Our Ref: EN020026

Date: 25 September 2025

## **Application by National Grid Electricity Transmission for an Order Granting Development Consent for the Sea Link Project**

### **Notification of Applicant's Intention to Submit a Request for Proposed Changes to the Development Consent Order (DCO) Application**

Document Title: APPENDIX B CONSENTED SPR OUTLINE LANDSCAPE MITIGATION OVERLAIN WITH THE SEA LINK OUTLINE LANDSCAPE MITIGATION FOR NGET SUBSTATION (SCENARIO 2)

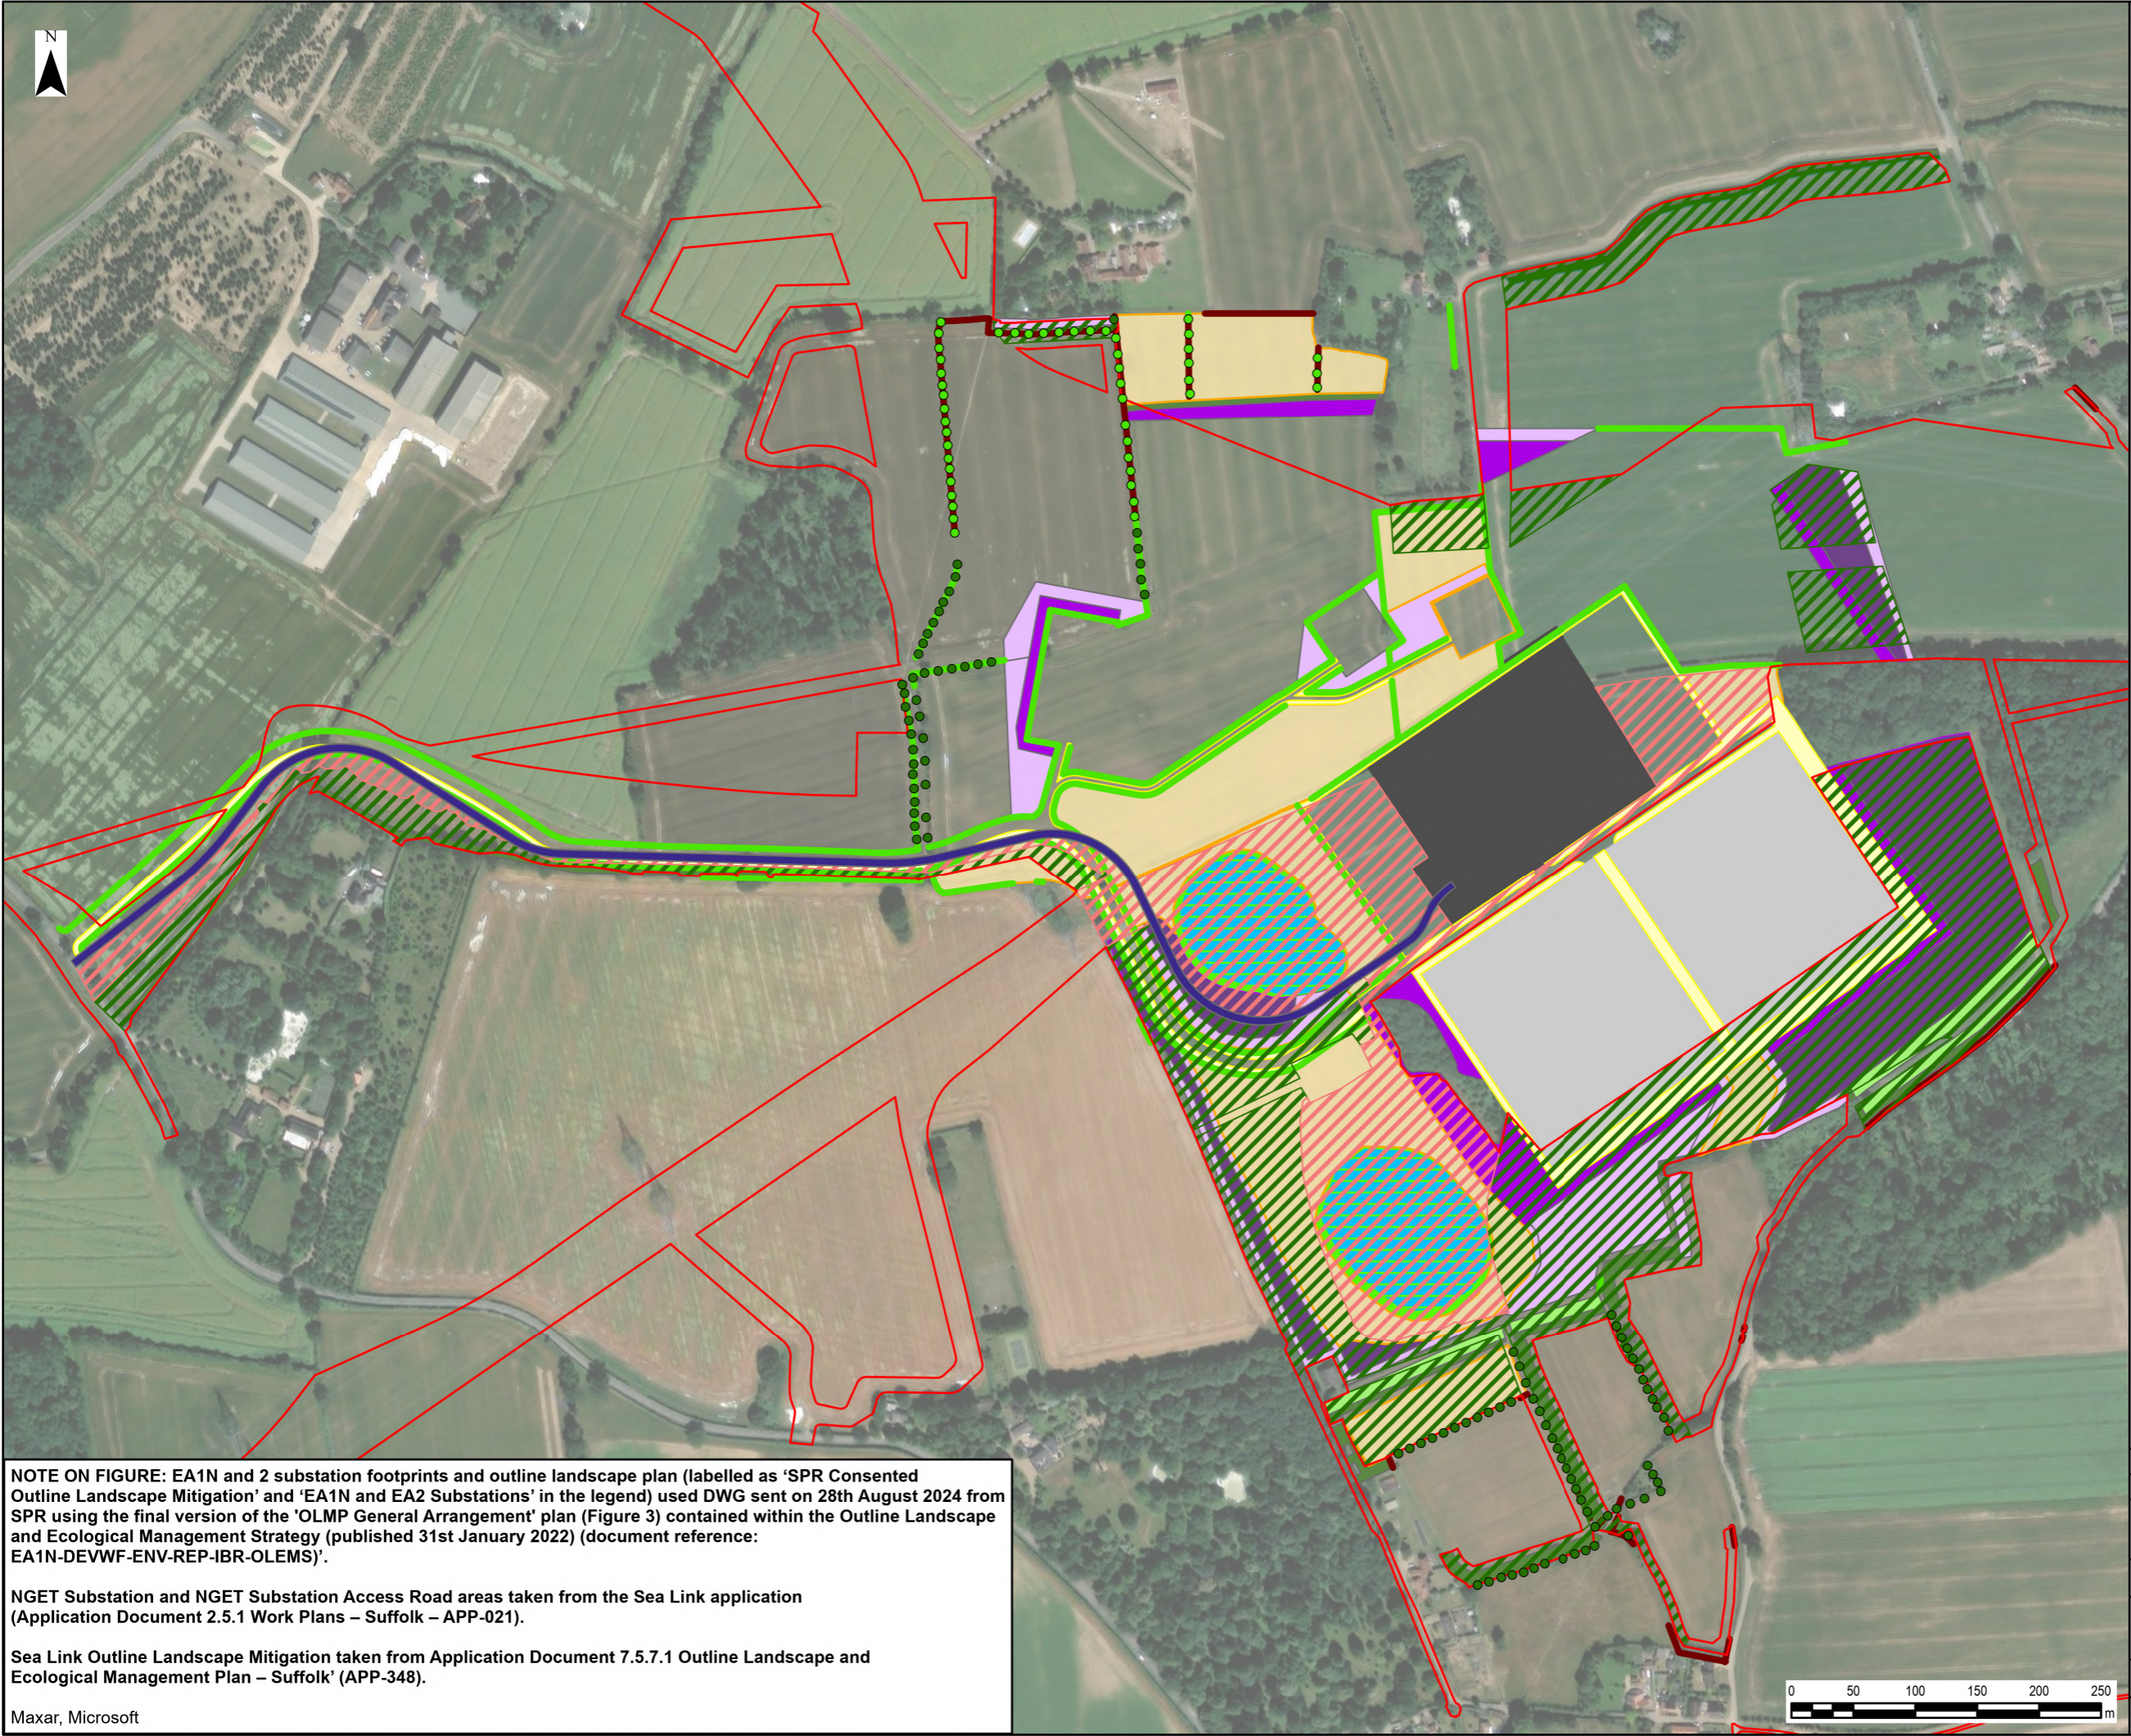
The applicant states that the proposed change is to extend the area for work 1B for Friston substation to align with those consented through the two Scottish Power Renewables (SPR) projects. This will either be presented as a proposed change to the limits of deviation (LoD) or a proposed change to the works area to align with the SPR works plans. In appendix B of [\[AS-138\]](#) it is presented as a revised LoD.

The ExA notes that the revised LoD extend northeast virtually up to the order limits adjacent to the woodland at Laurel Covert. When compared with the applicant's document [\[AS-063\]](#), the LoD would appear to conflict with the SPR consented outline landscape mitigation to the northeast of the proposed substation.

The revised LoD appear to occupy a larger footprint than work no. 41 of the made East Anglia One North (EA1N) Order, as shown on the onshore works plan certified by that Order (Project EN010077 sheet 7 of 12 [\[REP11-004\]](#)). Appendix B of [\[AS-138\]](#) also appears to show a smaller separation between the National Grid substation and Laurel Covert than that shown on figure 3 of the final Outline Landscape and Ecological Management Strategy [\[REP13-007\]](#) certified by the made EA1N Order.

LoD differs from the EA1N Order LoD. Please consider this in your proposed change application.

Document 9.3.3 Suffolk Section Phase 2B Archaeological Evaluation Report Extract illustrating the location of the henge in relation to the proposed scheme

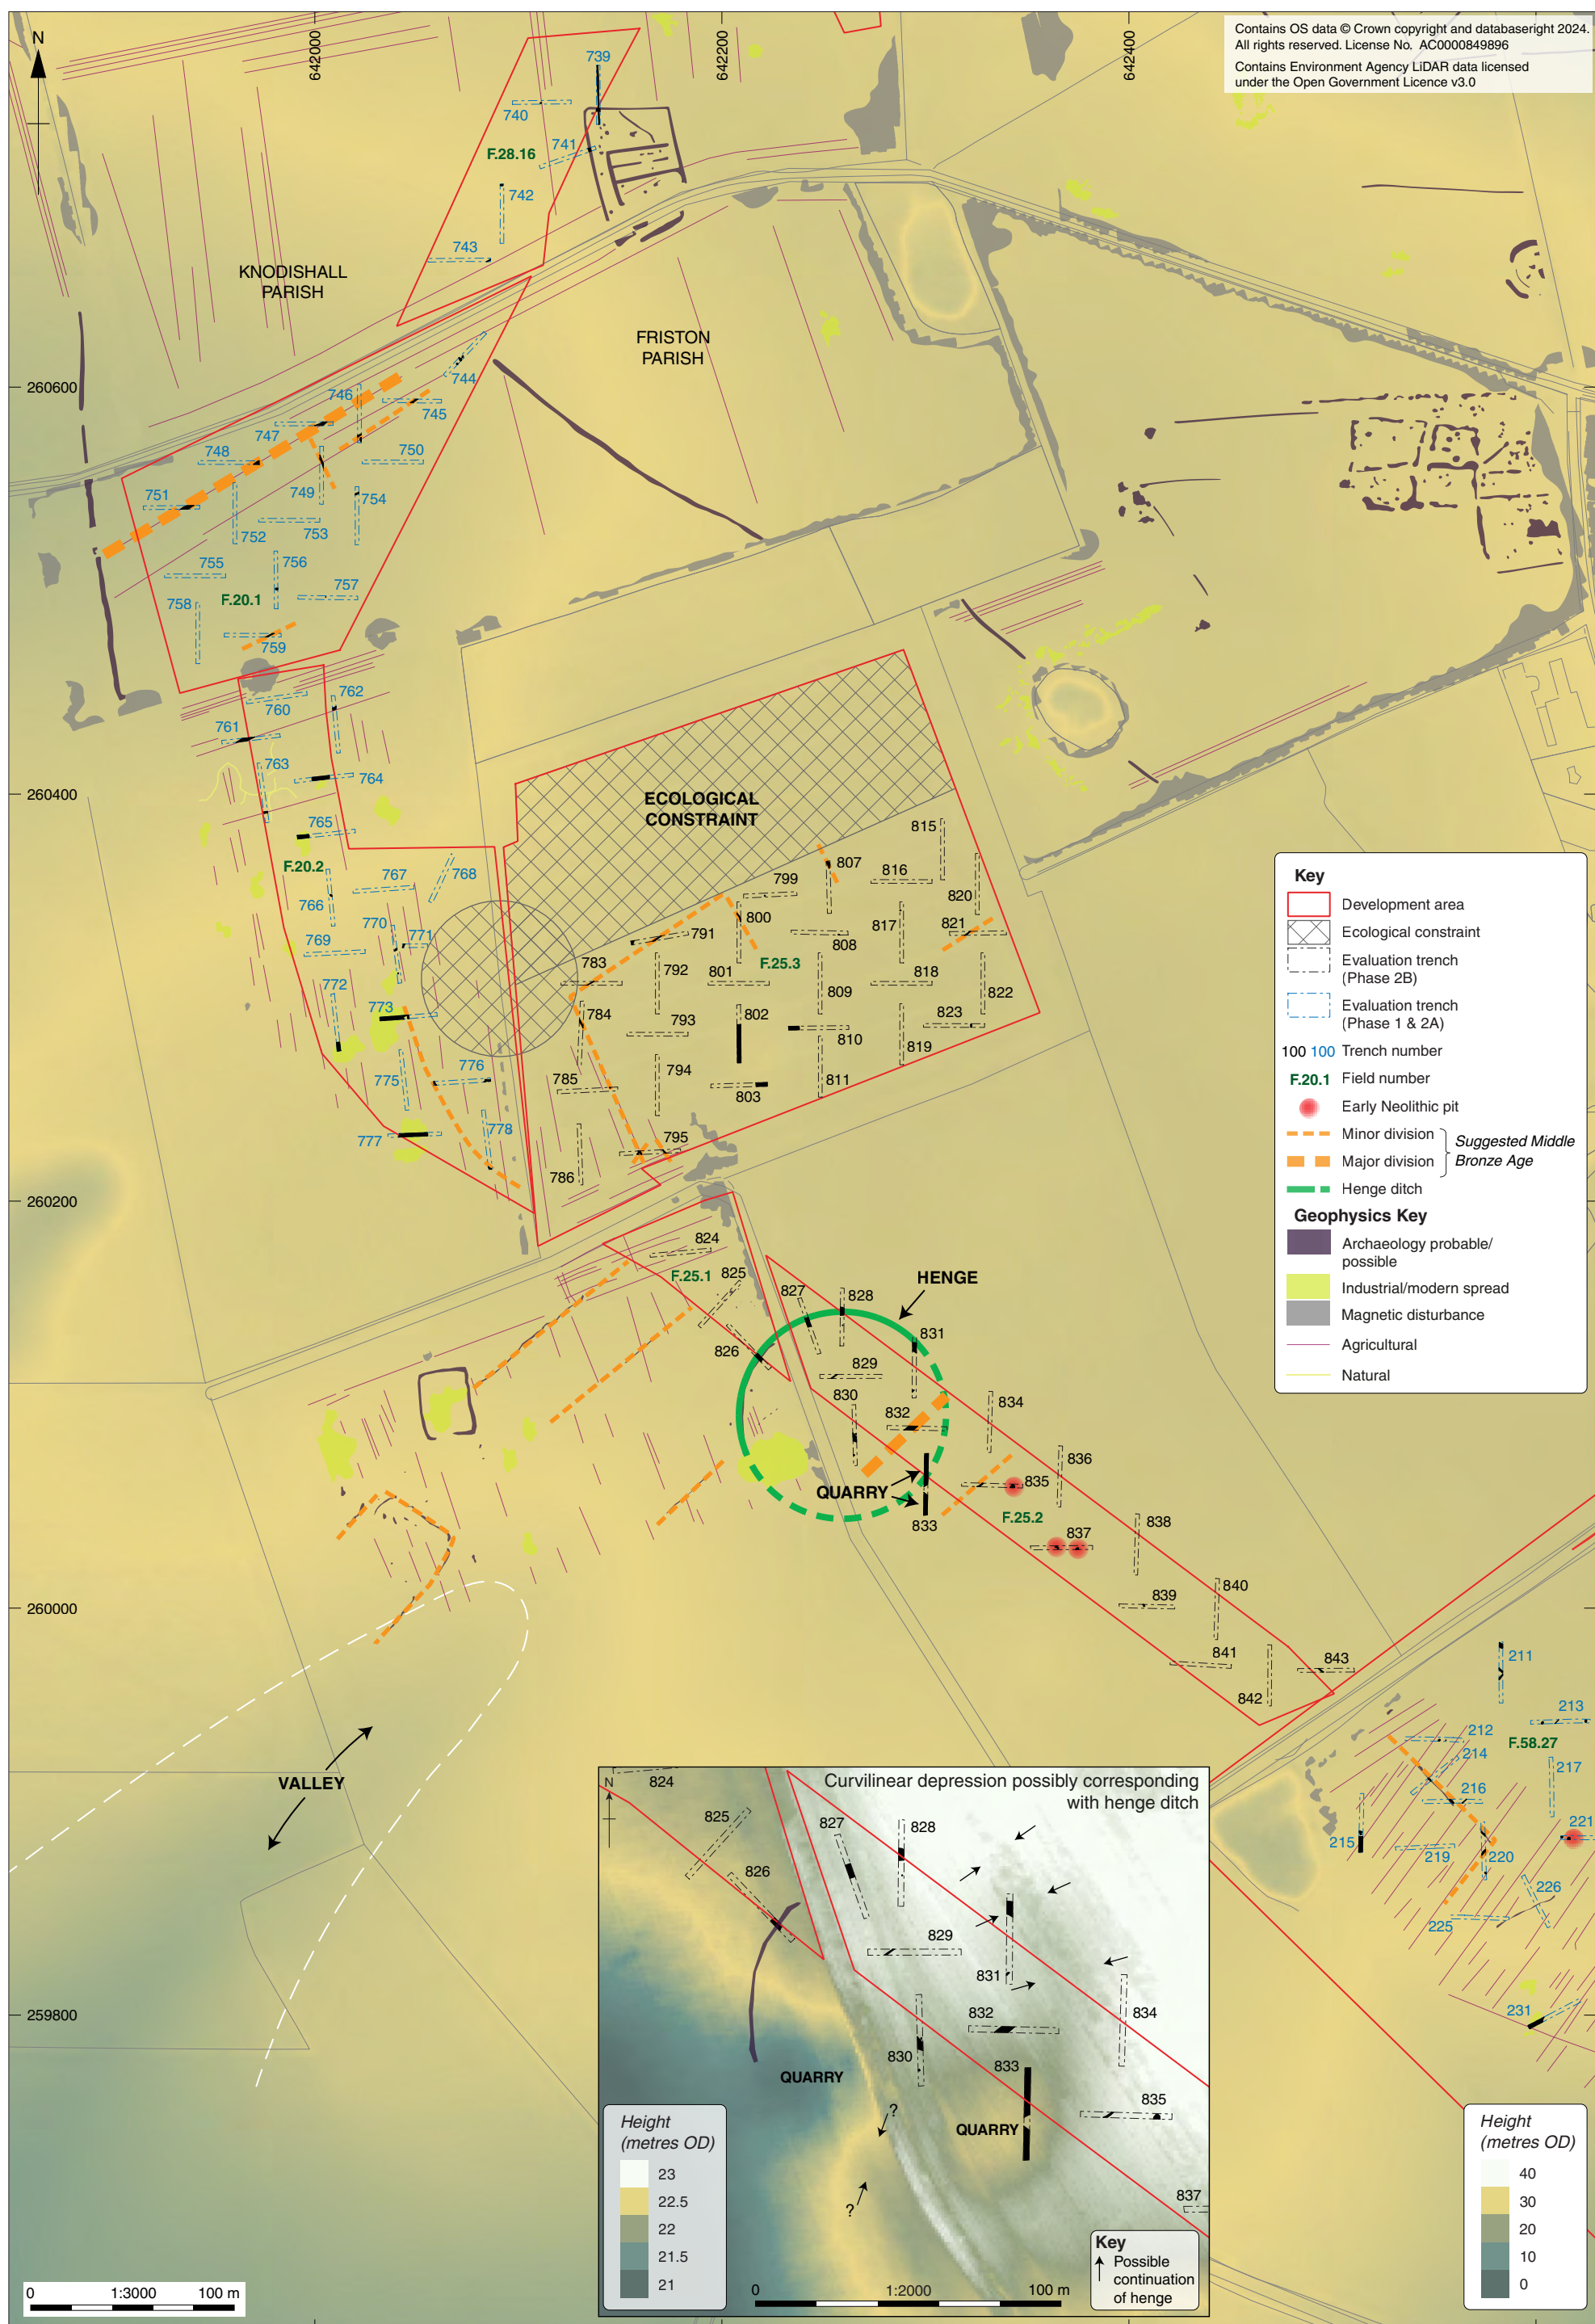
The ExA notes that there will be further archaeological investigative works on both the henge and the surrounding area in September and October 2025. If this provides sufficient information to set a route for the proposed cable to either the west or east of the henge, then the ExA expects this to be reflected in the order limits set out within the change application. If the full extent of flexibility as shown on the change notification figure in appendix C [AS-138] is sought in the change application, the ES addendum should justify this position and explain the process for selecting a final cable route.

As noted in [AS-138], the proposed alternative cable routes around the henge would be closer to neighbouring properties. The ExA expects that any resultant change to the potential impacts to neighbouring occupiers are addressed by the applicant.
